## **Letter of Intent** Site Development Plan

Randall Deyoung  
2790 N Academy Blvd # 150  
Colorado Springs, CO 80917  
Project name: Man Cave Storage

# Letter of Intent\_v1.pdf Markup Summary

SITE PLAN

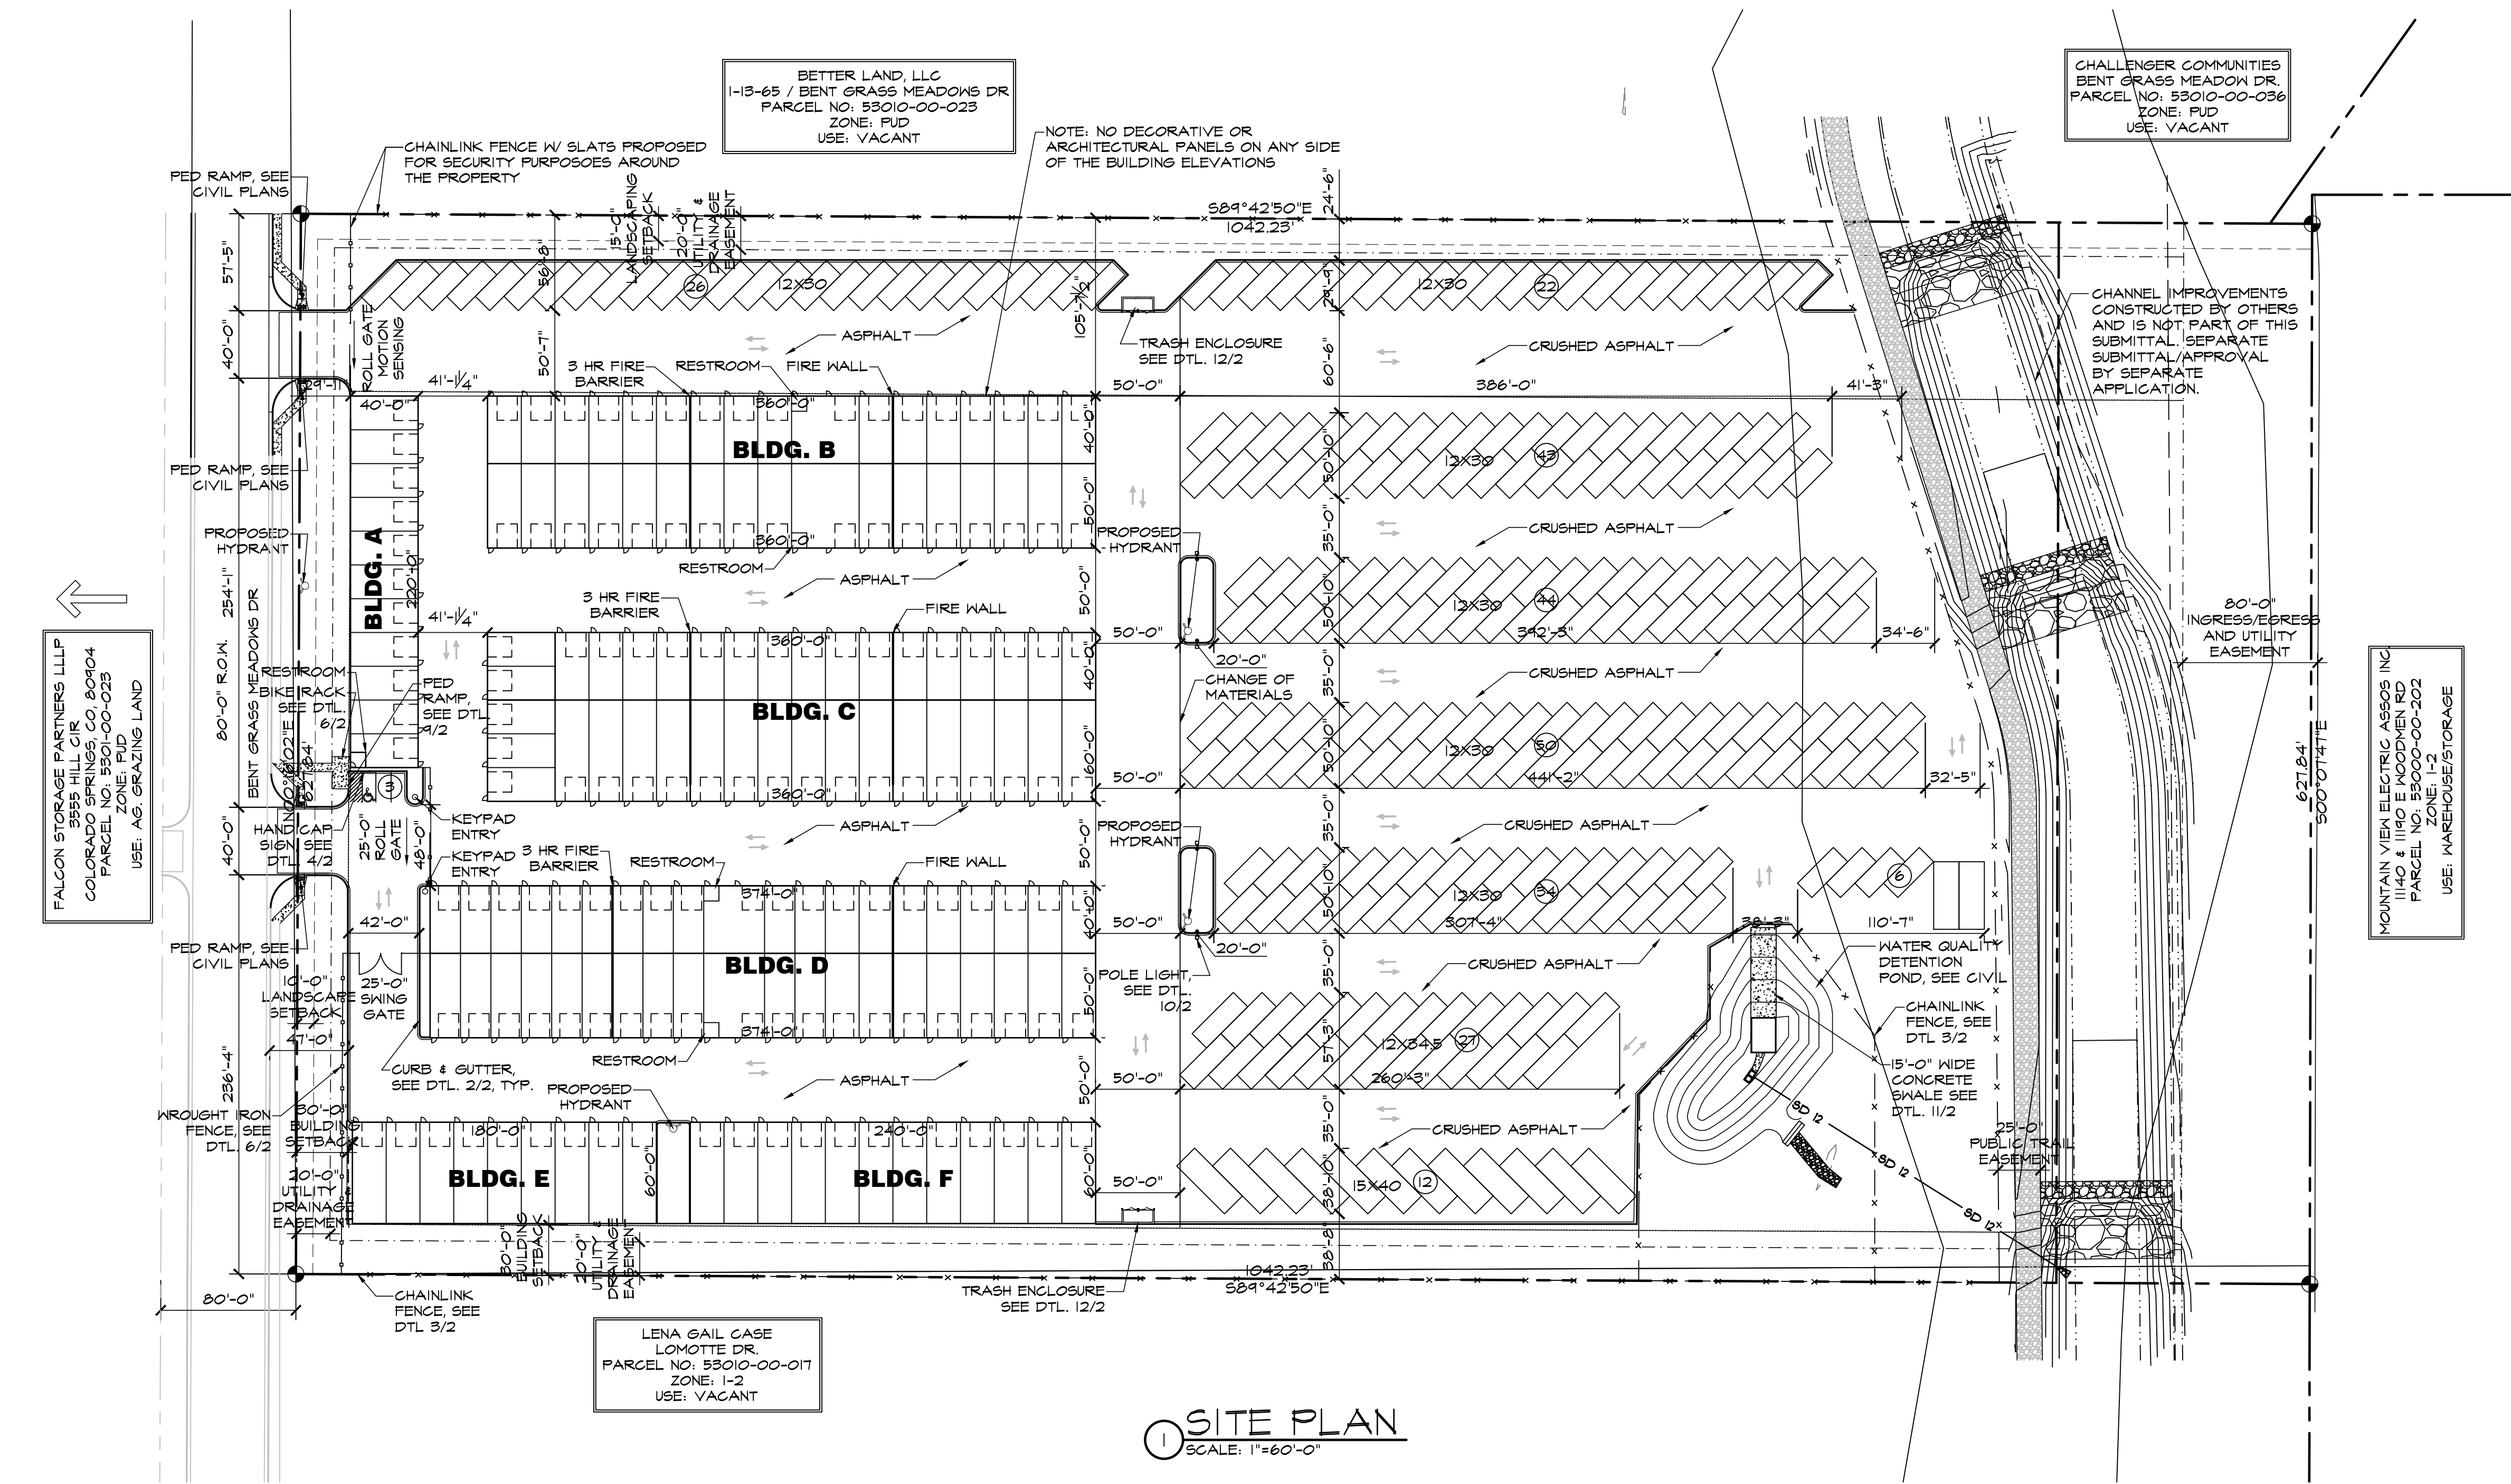
264 parking spaces?
